CITY OF ALBUQUERQUE

Re: Brewstiller
500 Yale SE
Traffic Circulation Layout
Architect's Stamp dated 02-05-16 (K15-D099)

Based upon the information provided in your submittal received 08-31-16, the above referenced plan cannot be approved for Building Permit until the following comments are addressed:

TCL
SHEET NO:
A1.2

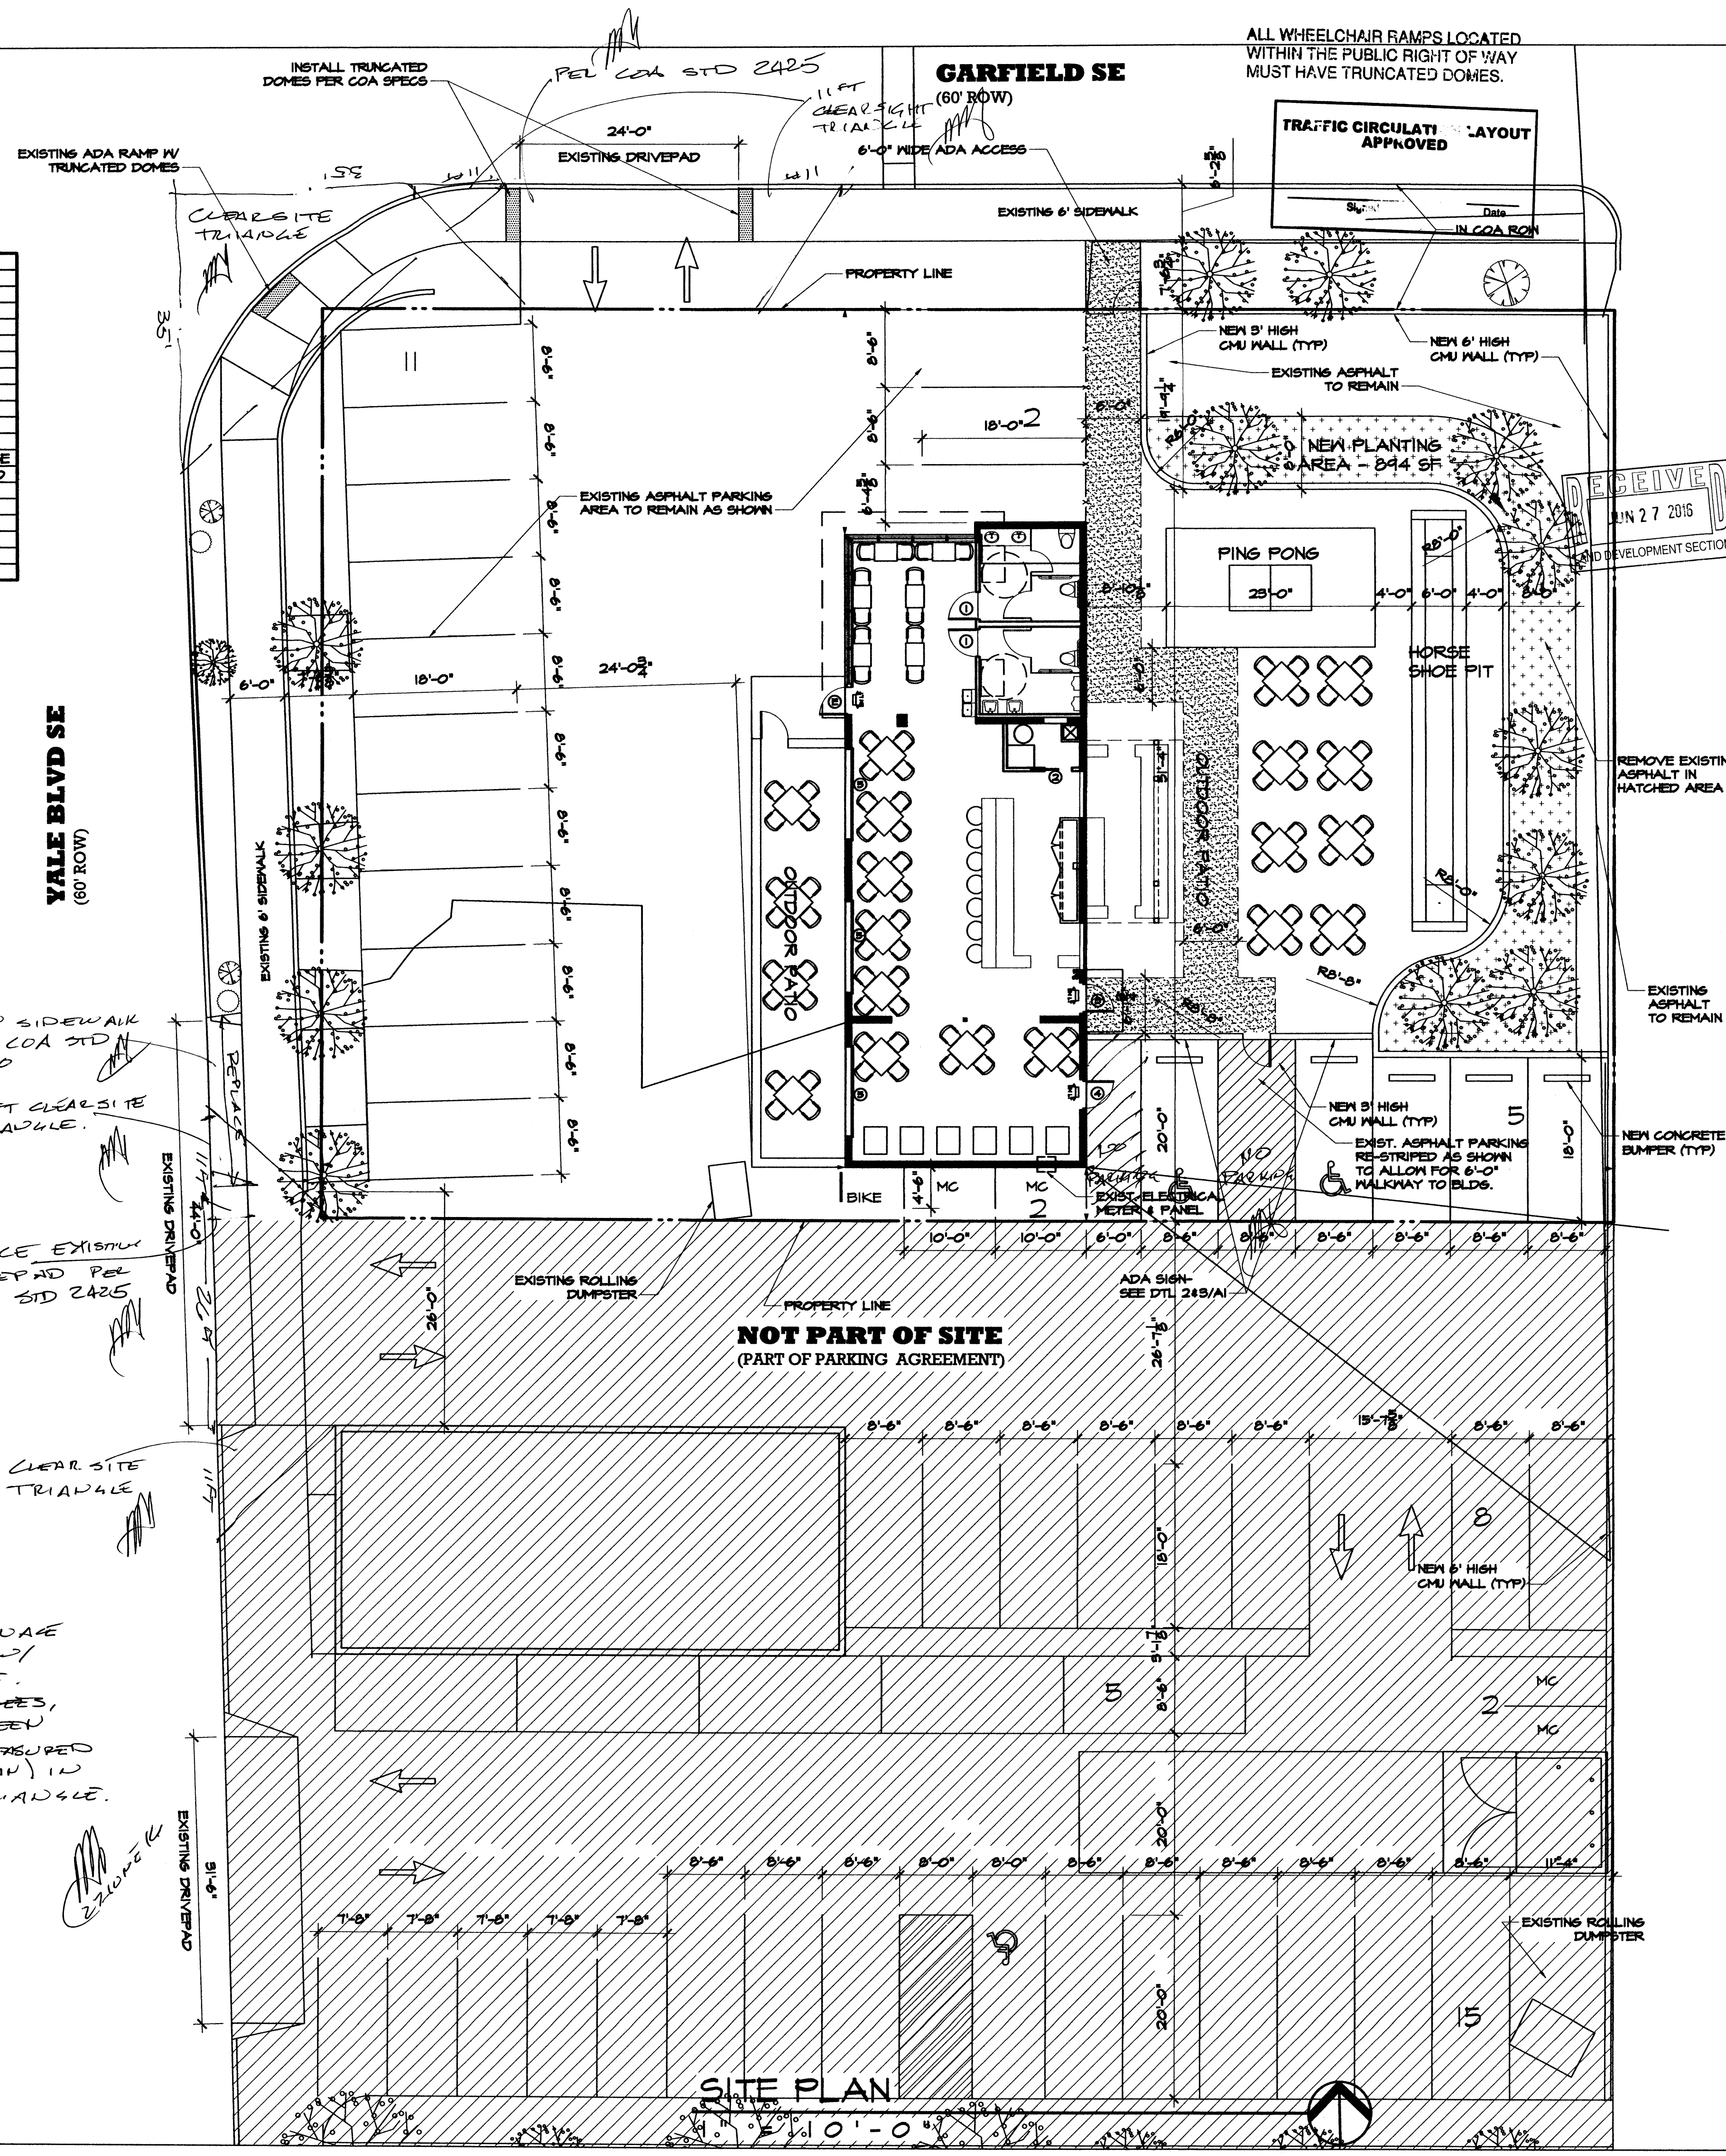
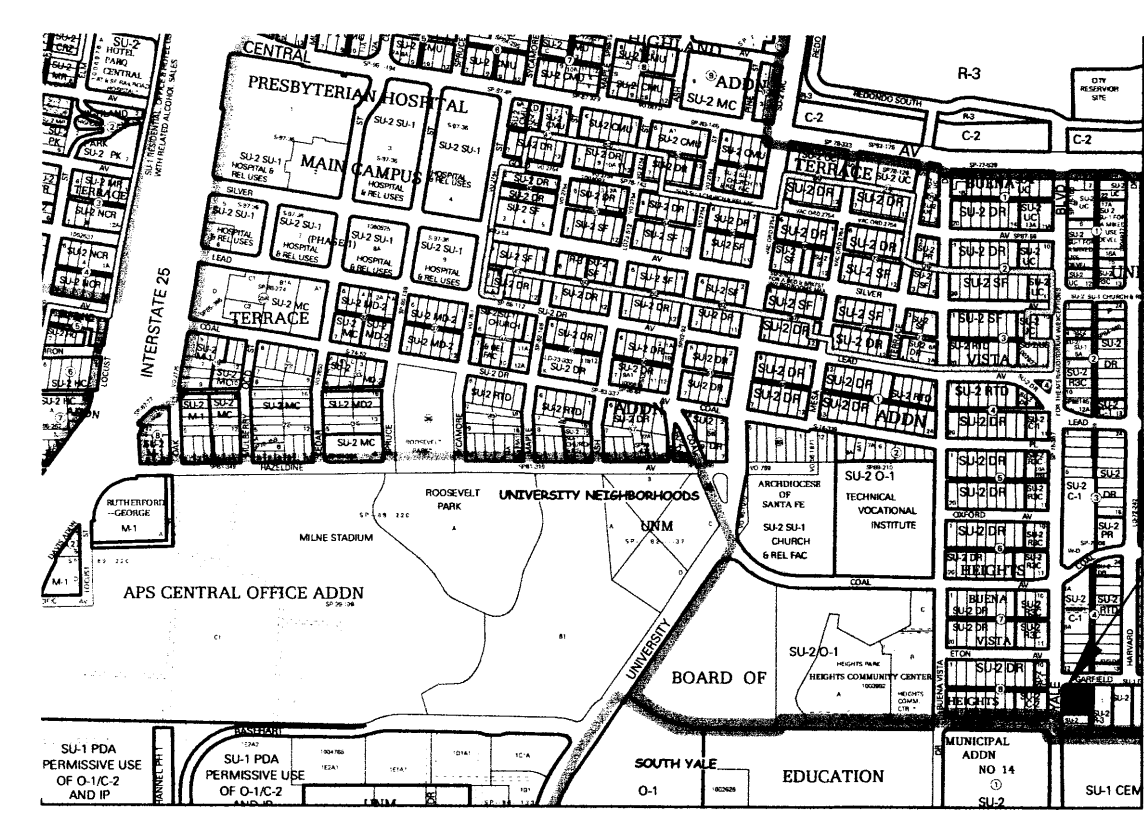
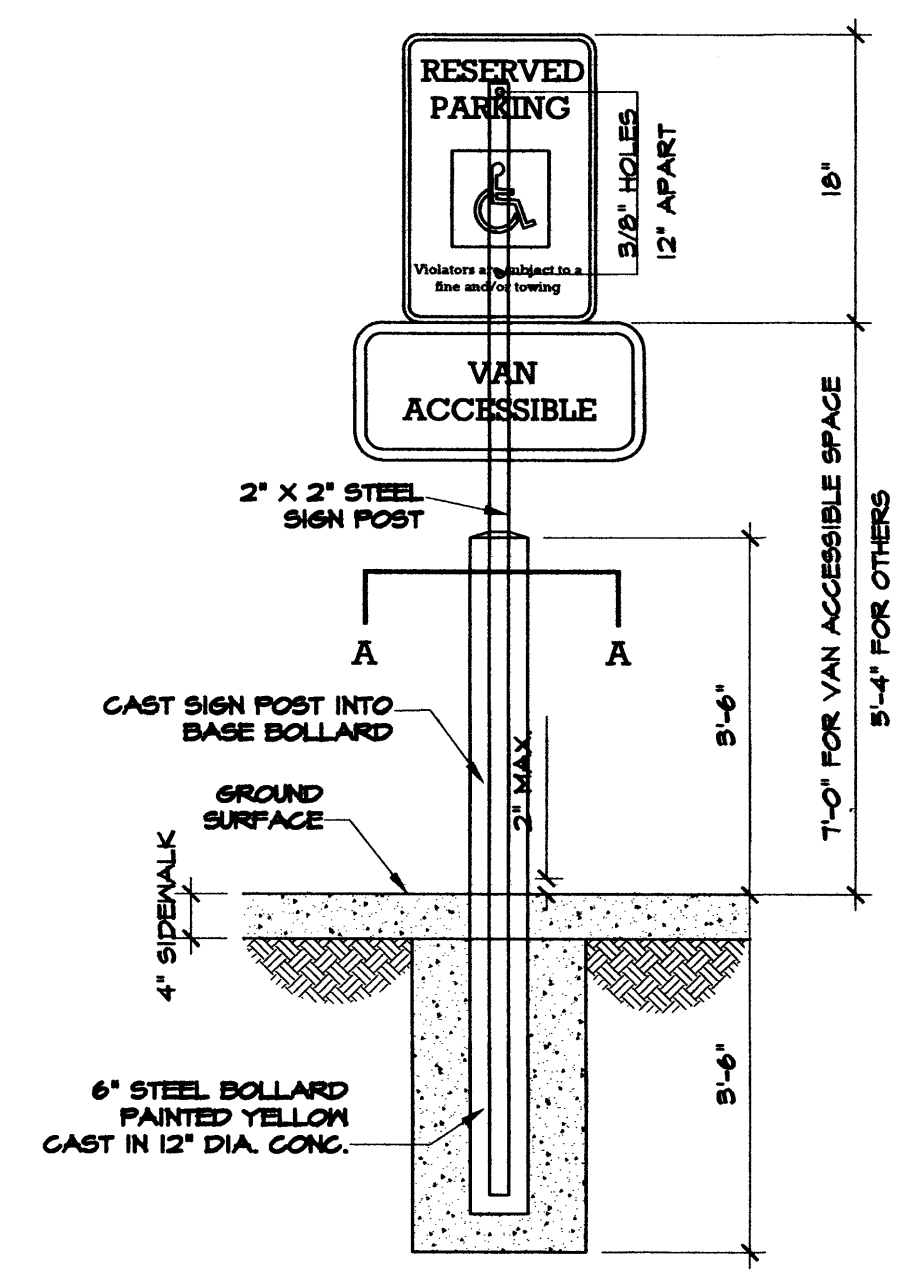
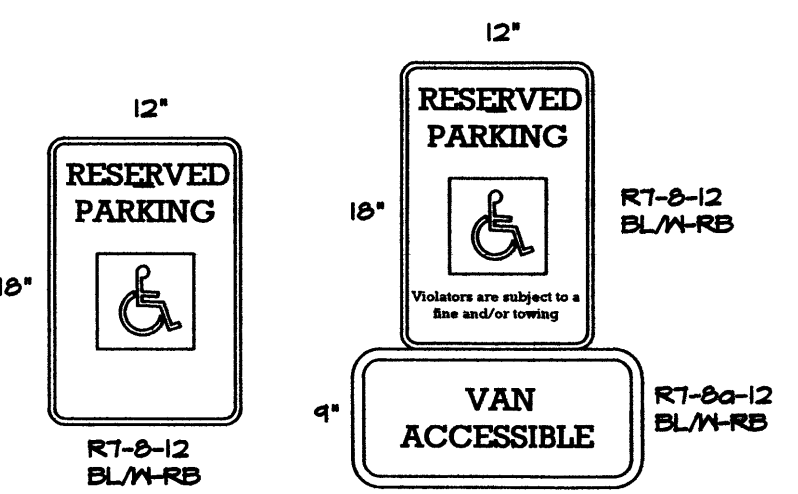
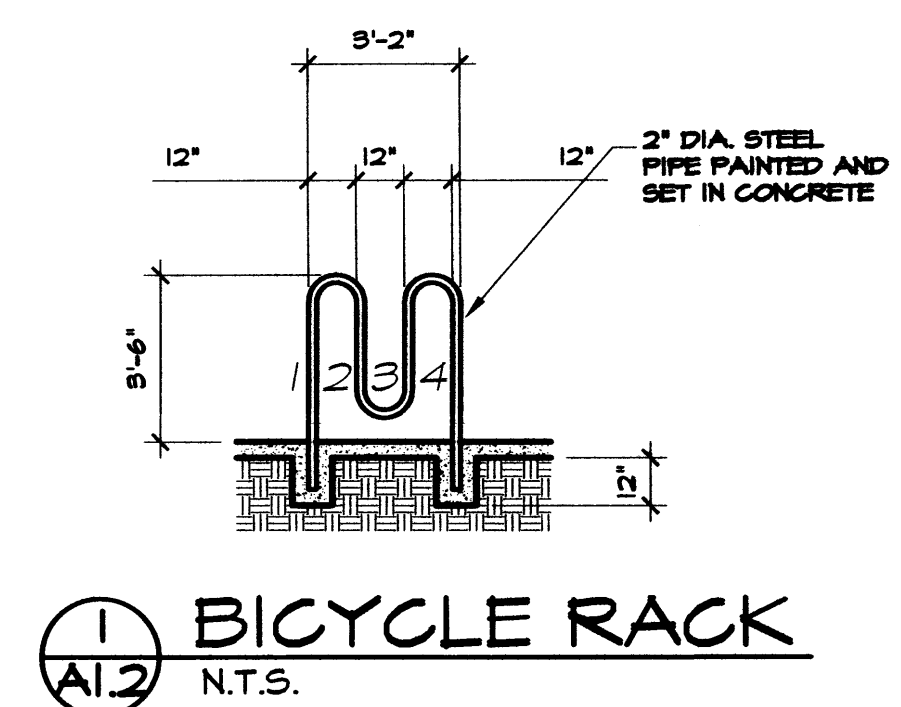
1. The ADA access aisles shall have the words "**NO PARKING**" in capital letters, each of which shall be at least one foot high and at least two inches wide, placed at the rear of the parking space so as to be close to where an adjacent vehicle's rear tire would be placed. (66-1-4.1.B NMSA 1978)
2. The existing curb cut on Yale Blvd must be reconstructed to match the existing dimension of the drive aisle on the property. It must be replaced with sidewalk and curb & gutter. A build note must be provided referring to the appropriate City Standard drawing.
3. Add a note stating "All broken or cracked sidewalk must be replaced with sidewalk and curb & gutter." A build note must be provided referring to the appropriate City Standard drawing.
4. Please include two copies of the traffic circulation layout at the next submittal.
